# **East Anglia ONE North and East Anglia TWO Offshore Windfarms**

## **Applicants' Comments on Natural England's Deadline 4 Submissions**

Applicant: East Anglia TWO and East Anglia ONE North Limited  
Document Reference: ExA.AS-3.D5.V1  
SPR Reference: EA1N\_EA2-DWF-ENV-REP-IBR-001218

Date: 3<sup>rd</sup> February 2021  
Revision: Version 1  
Author: Royal HaskoningDHV

Figure 6 Modelled distribution of red throated divers for years preceding windfarm construction. This is purely in order to provide interpretable numbers for the colour scale used in the maps and should not be seen as an accurate estimation of absolute population densities

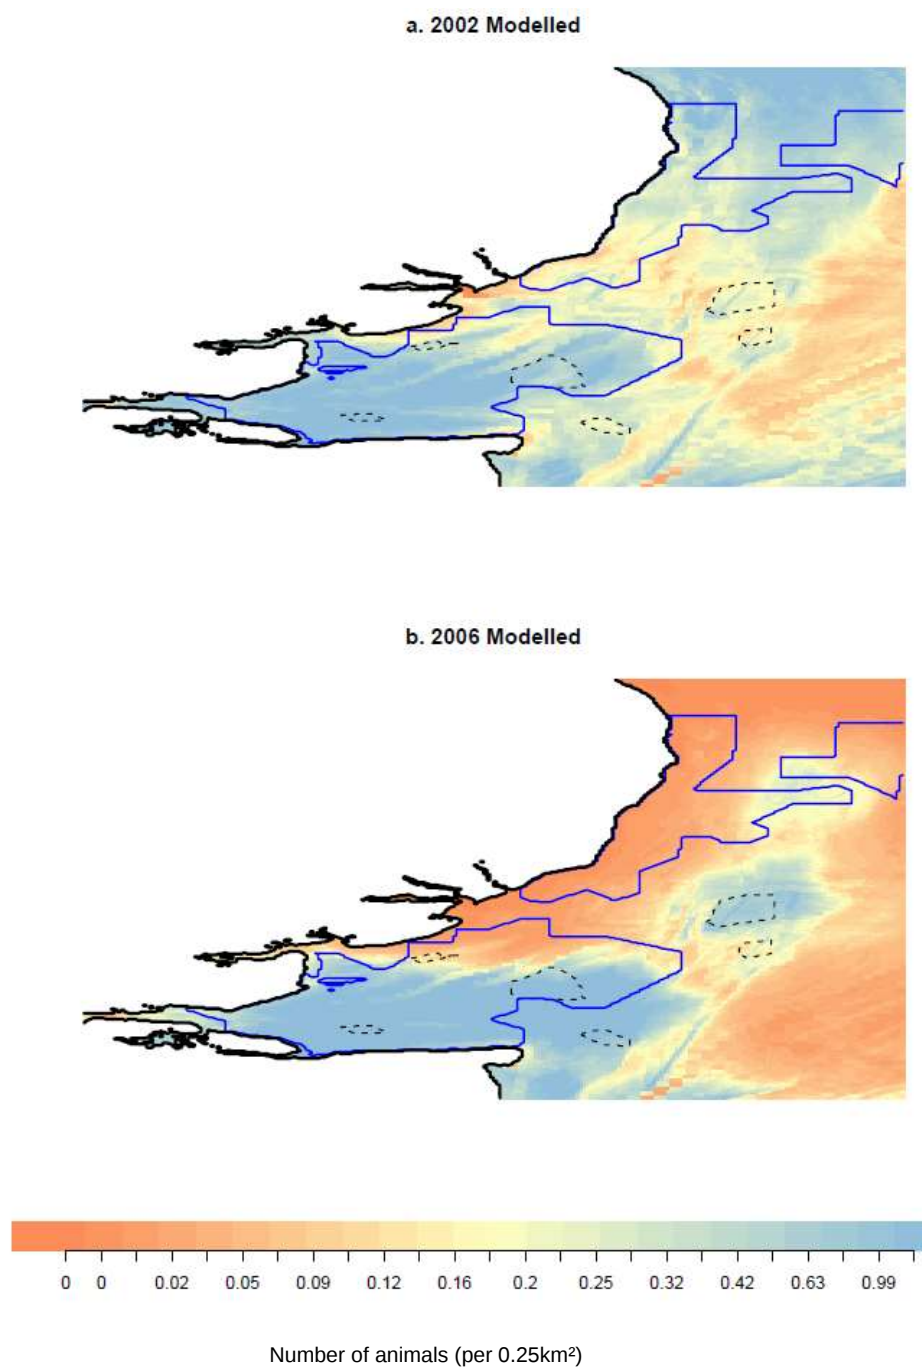
015	We note that the relative diver distributions in Appendix 1 figure 6a and 8a are very similar. The remarkably similar distributions between factualls and counterfactuals (Appendix 1 figures 7 and 8) are likely due to the fact that the covariates used are mostly static, and if distance to windfarm is not strongly influencing predictions, removing it or changing it as a parameter should not greatly impact predictive output. Counterfactuals were created here to act as a baseline for which to compare model predictions. This was done by simply changing the distance to windfarm parameter to represent the	The Applicants have interpreted the spatiotemporal term in the selected model to include missing covariates or intrinsically driven species aggregations, but no direct effects of windfarms. This carries the implicit assumption that there are no residual effects of distance to windfarms that are not captured by the distance-to-windfarm term itself. We base this on the fact that distance to windfarms is known with high accuracy and the time points at which different windfarms are introduced to the system are also precisely known. Most importantly, the distance to windfarm term is modelled
